KITTITAS COUNTY DEPARTMENT OF PUBLIC WORKS

MEMORANDUM

TO: All Staff
FROM: Public Works Plan Review Team
DATE: May 31, 2024
SUBJECT: BL-24-00008 Palmer

Critical Areas Map

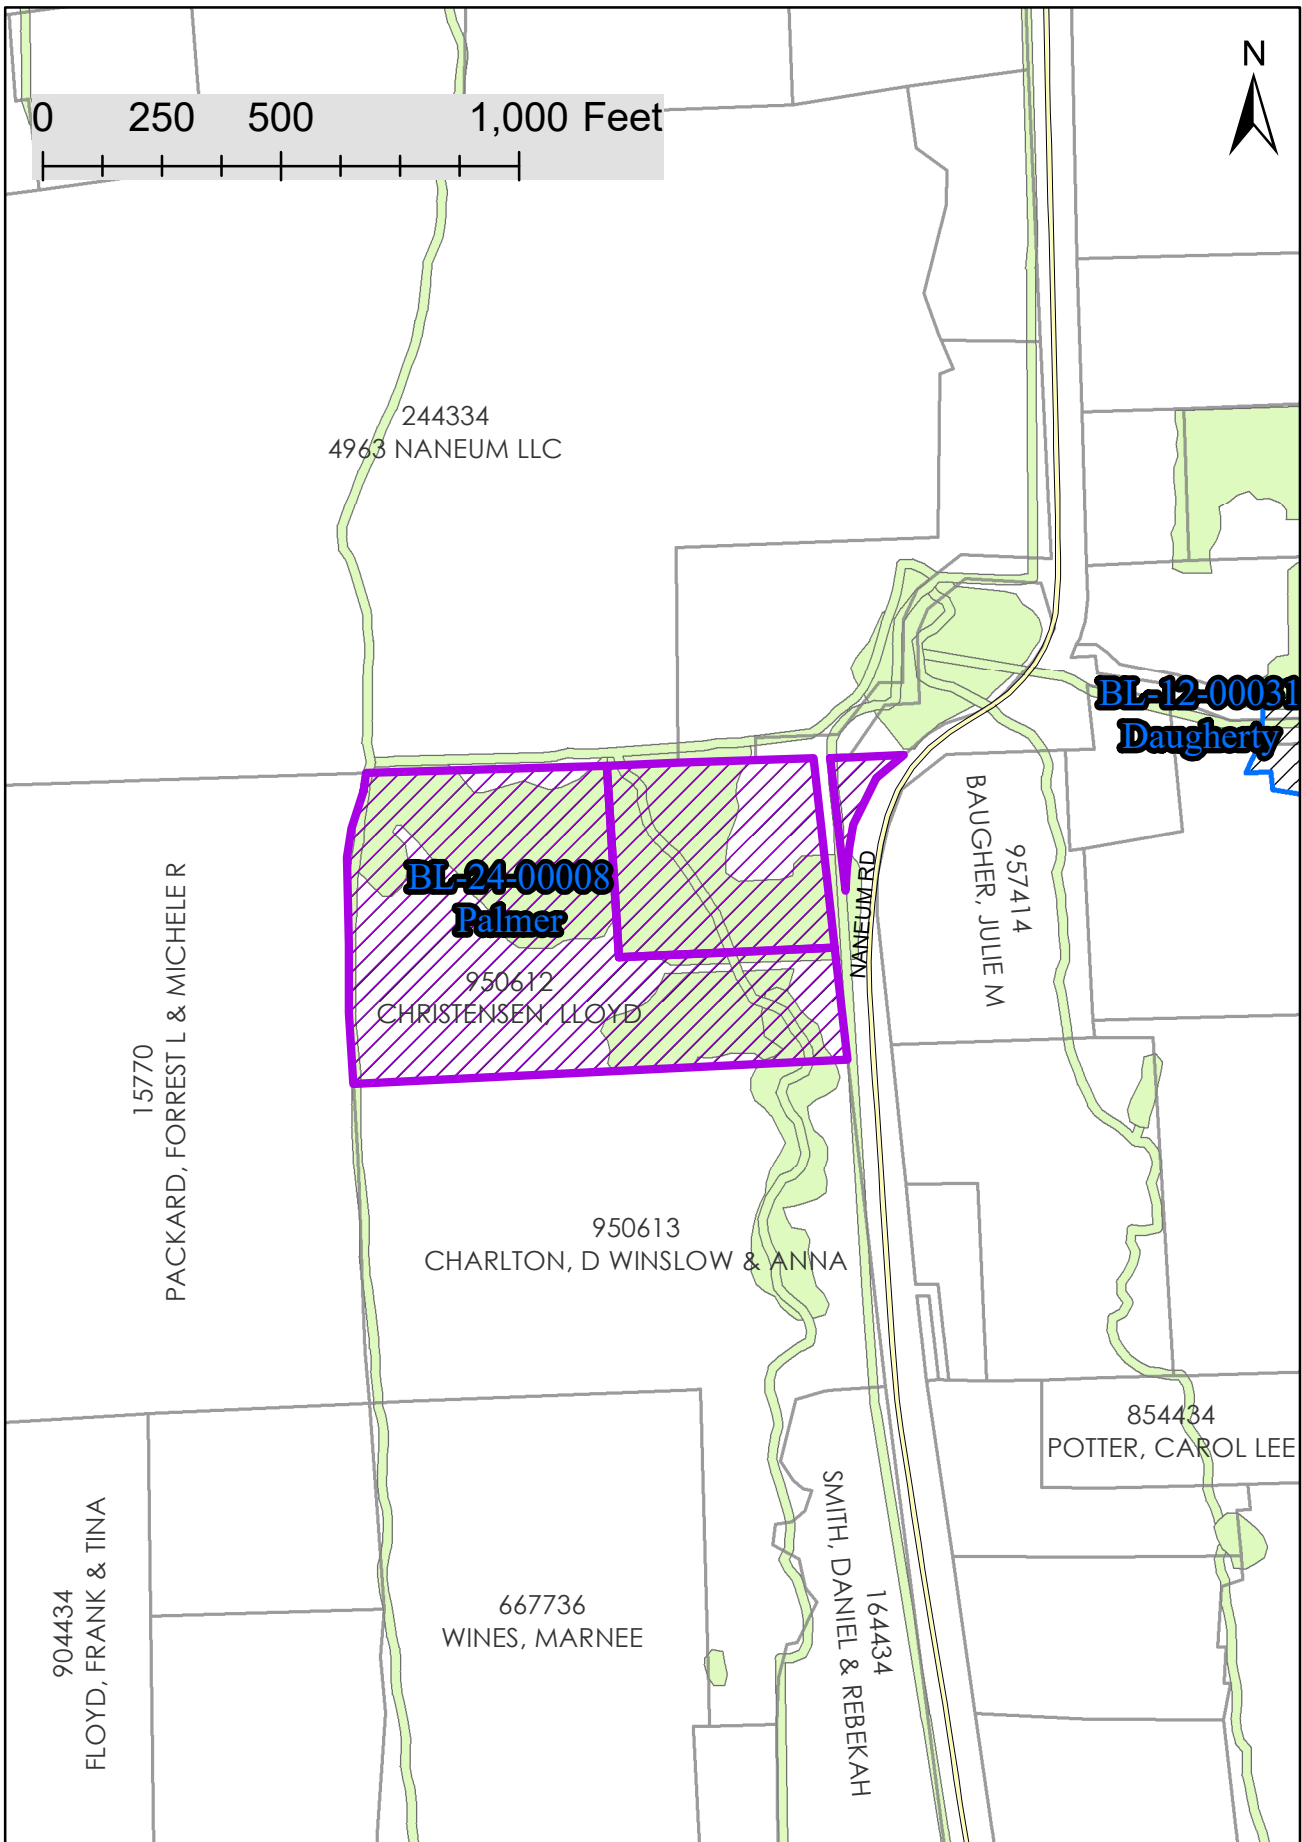
FLOOD	<p>A portion of the proposed parcels are within the 100-year floodplain boundary. If possible, any future development should remain outside of the floodplain in order to reduce risk and avoid mandatory flood insurance purchase requirements. All activities within the floodplain must be permitted through the floodplain development permit process and follow the regulations within KCC 14.08.</p> <p>While not required by KCC 14.08.220, it is highly encouraged that the floodplain boundaries are outlined on the face of the recorded survey. (SC)</p>
WATER MITIGATION/ METERING	No comments. (SC)
AIRPORT	No Comments. (TM)
